Submission on the Concept Development Application SSD-82899468 (1–5 Nelson Rd, Lindfield)

NORTH ELEVATION

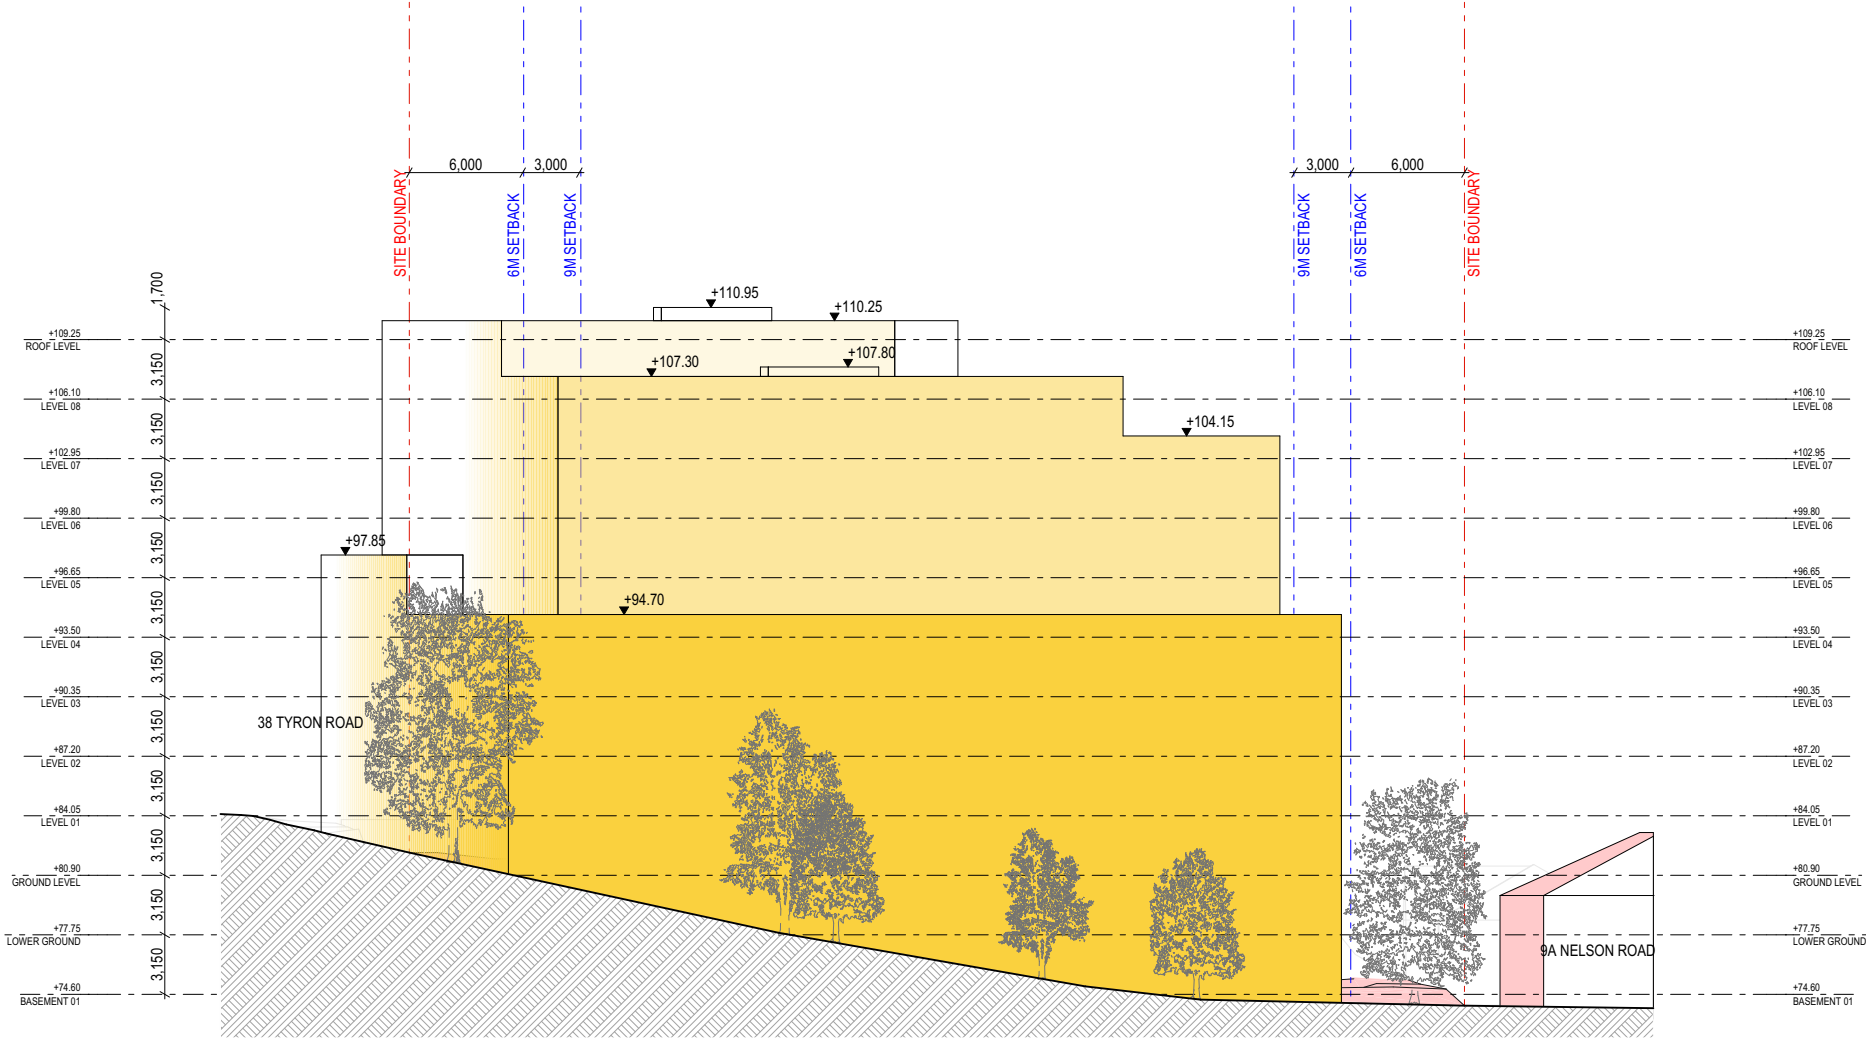
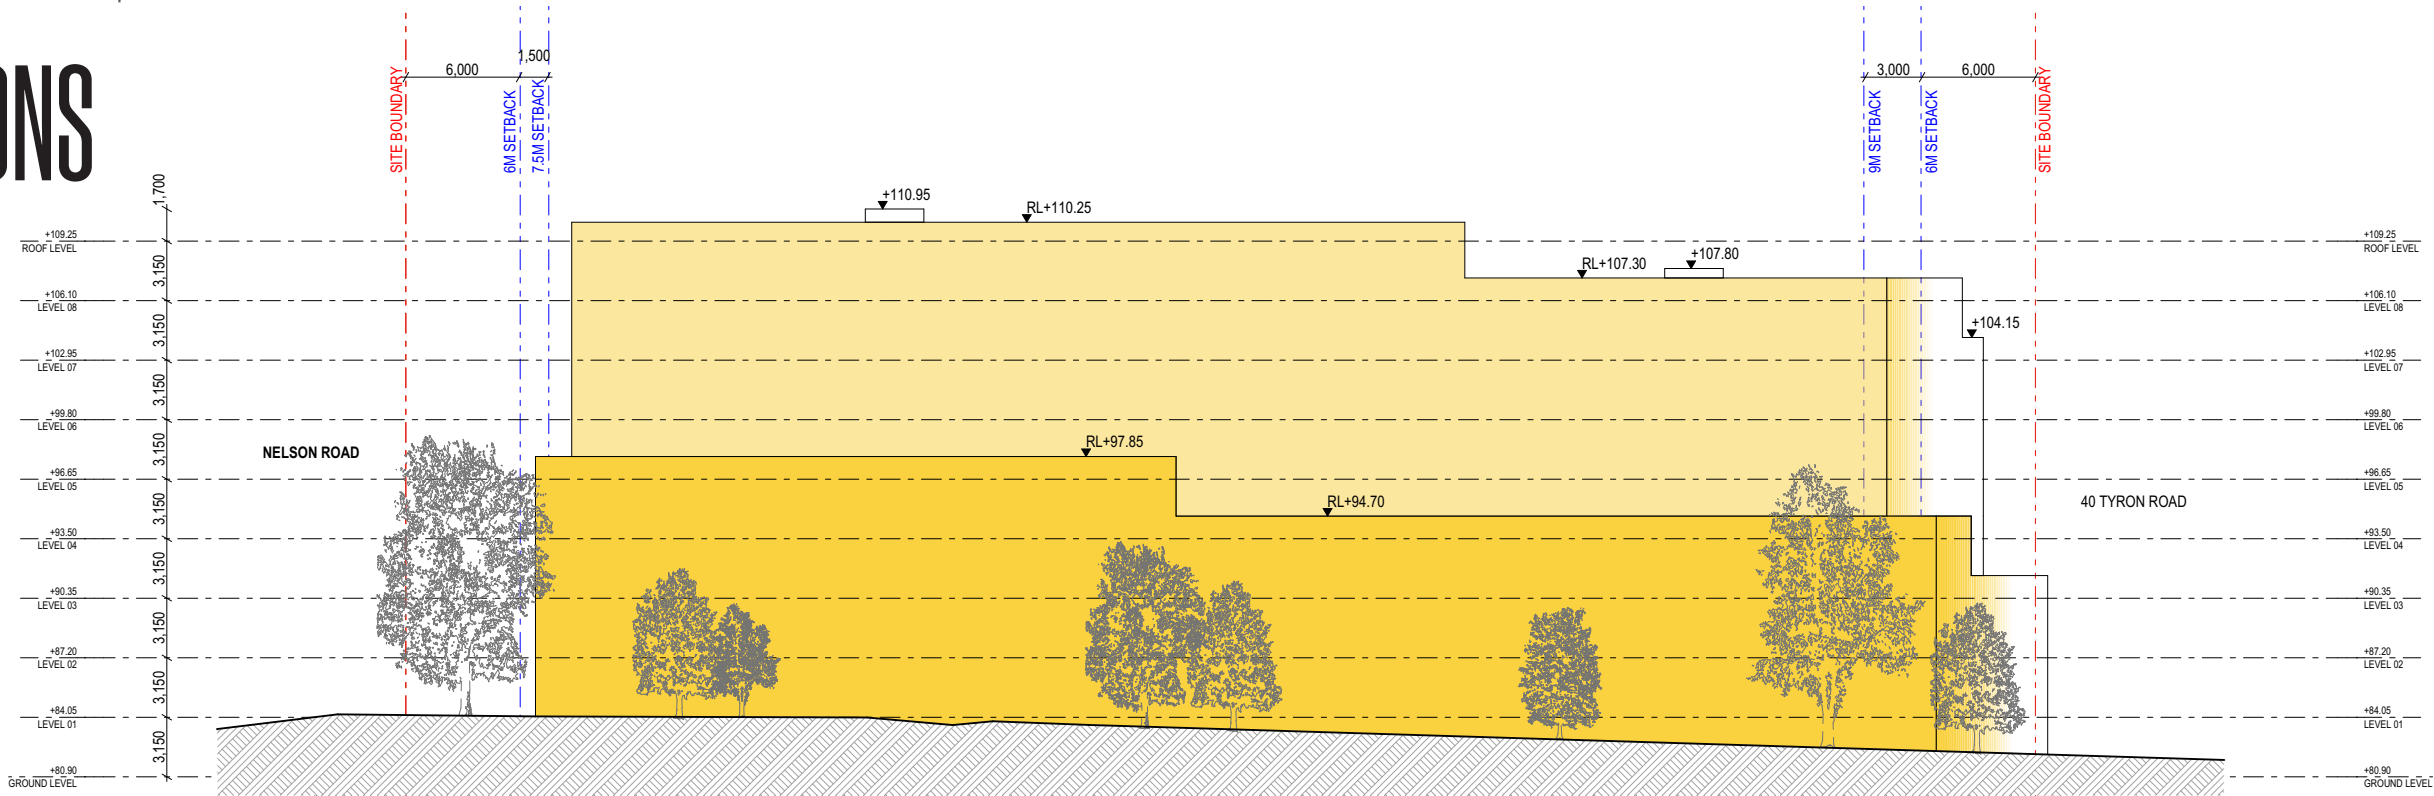
The **proposed building's height (>32m over nine storeys) significantly exceeds established height controls** for this locality. A planning system is effective only if its development standards are respected and enforced. Allowing this precedent—in the face of community and expert opposition—**will undermine the integrity of the zoning system, encourage further speculative over-height proposals, and ultimately destabilise the planning framework's ability to deliver fair, orderly, and predictable development outcomes.**

Good **design principles call for careful modulation and step-downs to manage transitions between built forms of markedly different scale.** The abrupt nine-storey shift alongside single or double-storey homes is poor practice, unnecessarily eroding neighbour amenity, overshadowing rear yards, and creating an overbearing visual impact. **Instead of a step down, it creates a perverse, one-off 'step-up' in height** as the viewer moves his/or her line of sight away from the station and commercial precinct of Lindfield, including the Pacific Highway.
